CITY OF PORTLAND BUILDING PERMIT

Located At 710 FOREST AVE

Job ID: 2012-03-3559-CH OF USE

has permission to Change the Use of 1500 sf on Saunders Street side from unknown to Used Cars Sales/Repair provided that the person or persons, firm or corporation accepting this permit shall comply with all of the provisions of the Statues of Maine and of the Ordinances of the City of Portland regulating the construction, maintenance and use of the buildings and structures, and of the application on file in the department.

BUILDING SKETCH
169'

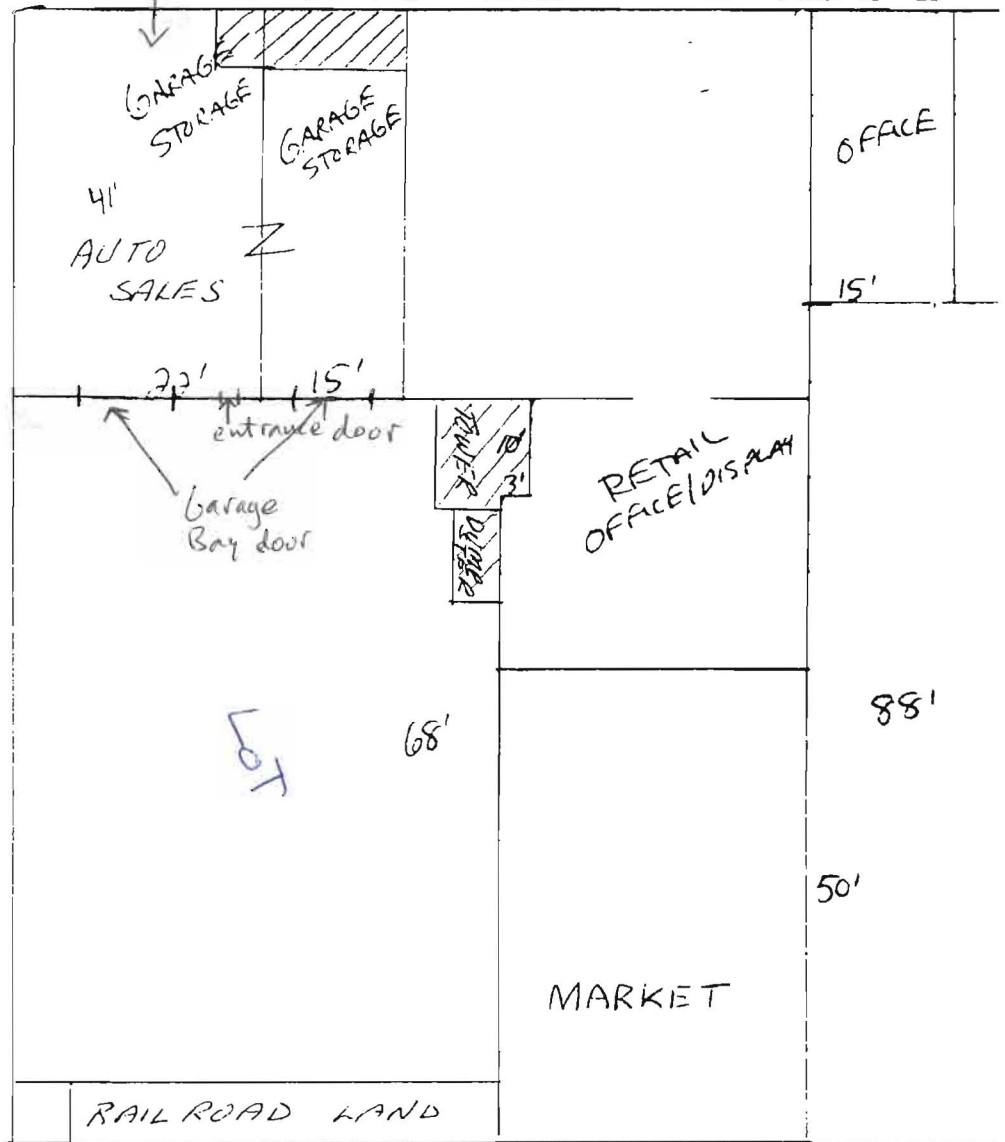
Section 14-339 requires a continuous curb guard for cars parked within ten feet of any street line. The plans do show that a curb guard is currently in place. I did not see any detail of that curb guard.
